## Submission to Western Harbour Tunnel and Warringah Freeway Upgrade EIS 30<sup>th</sup> March 2020

### Objection: Western Harbour Tunnel and Warringah Freeway Upgrade - SSI-8863

Anna Bragg  
President P&C  
Cammeray Public School P&C

Figure 12-22 Annual mean PM_{2.5} concentration at community receivers

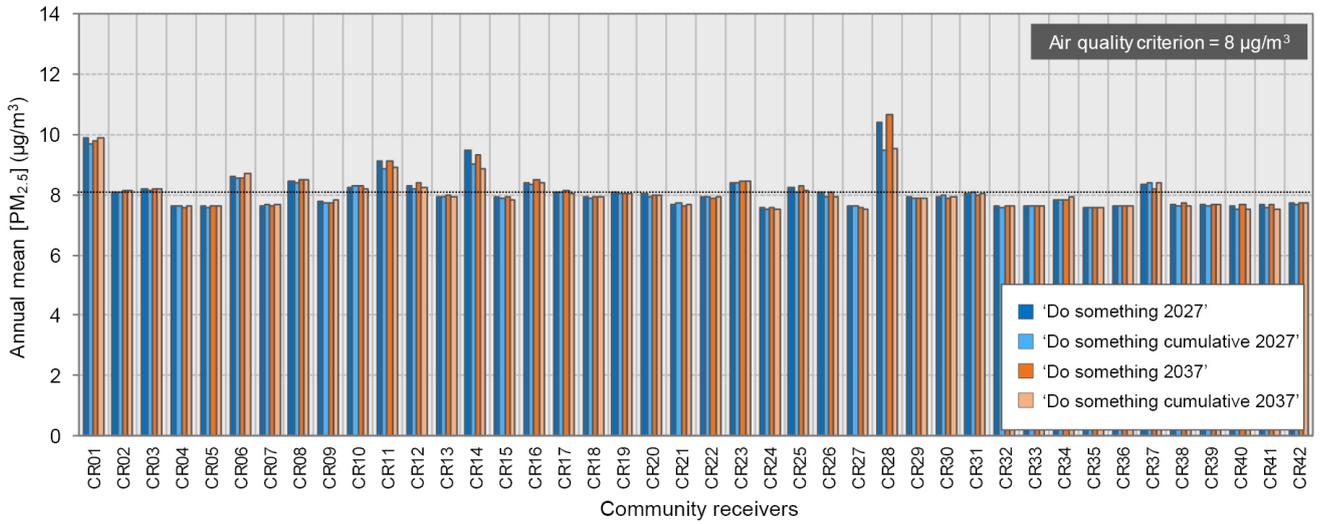
**Pollution:** (Here [for a summary table of pollution impacts](#)): The ventilation stack servicing the 6.5km stack at Cammeray will not be filtered. The EIS demonstrates concerning impacts in terms of pollution for CPS and its' catchment. All areas will see overall PM2.5 levels well about national criteria when project opens. CPS will experience increases in pollution across NO2, PM10 (annual) and PM2.5 (which WHO states no safe limit). Concerningly our local parks will also be impacted by increased pollution including Green Park, Cammeray Oval, St Leonard's Park and Bicentennial Reserve. Children are most susceptible, particularly at higher respiration rates. The stacks have no emergency ventilation outlets and so fumes from any high pollution events or emergencies will be dispersed over schools in the area. A summary of the CR sites that show an increase in pollution across both projects is attached. Air pollution has been averaged out across a wide span of CR sites which appear unrelated to the Western Harbour Tunnel. As no traffic analysis has been done on Willoughby Rd for example it is hard to claim Roseville is impacted. FOR WHT only relevant sites should be included in the analysis and results should be weighted by number of sensitive receivers. One graph has results covered by the key and the PM2.5 tables do not show the correct criteria level with criterion to be lowered by 2025. [Appendx B](#). Increased rat running due to ramp and accessibility changes will also re-distribute pollution to residential areas increasing the burden on sensitive receivers.

**Figure 12-22 Annual mean PM<sub>2.5</sub> concentration at community receivers**  
7 µg/m<sup>3</sup> legislated by 2025

**Reissue:** the air quality analysis should be completed showing the actual risks to each school in the area (ie CR's should be weighted based on sensitive receiver) taking into account relative elevation and risk, clear information about which houses will have substratum acquisition should be published, reissue visual amenity pictures with clearer artists impressions showing actual buildings.

Figure 12-23 Change in annual mean PM_{2.5} concentration at community receivers

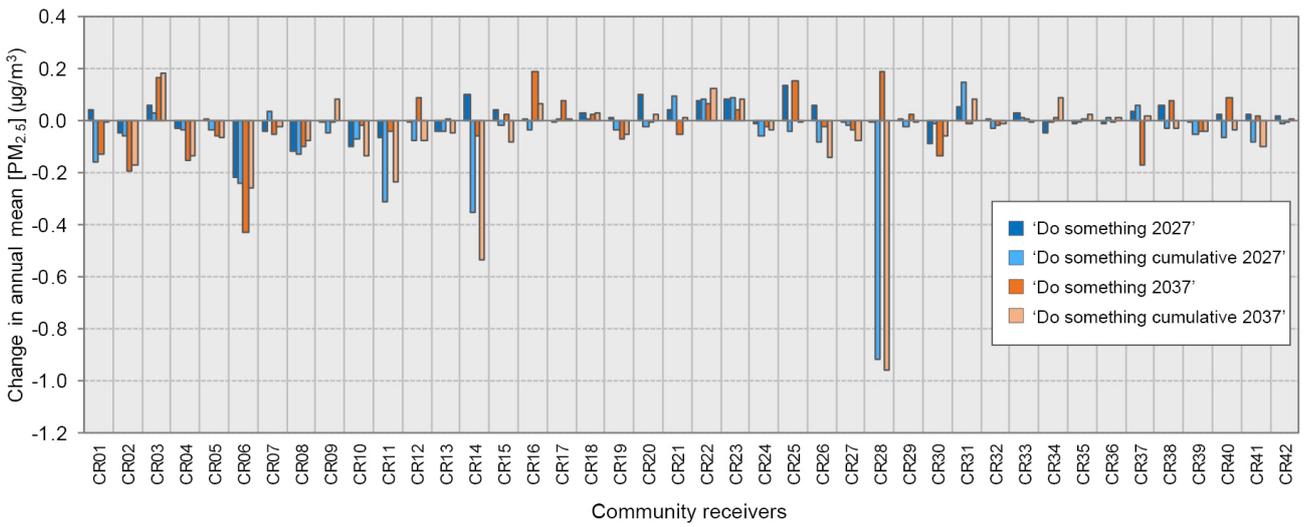
**Figure 12-23 Change in annual mean PM<sub>2.5</sub> concentration at community receivers**
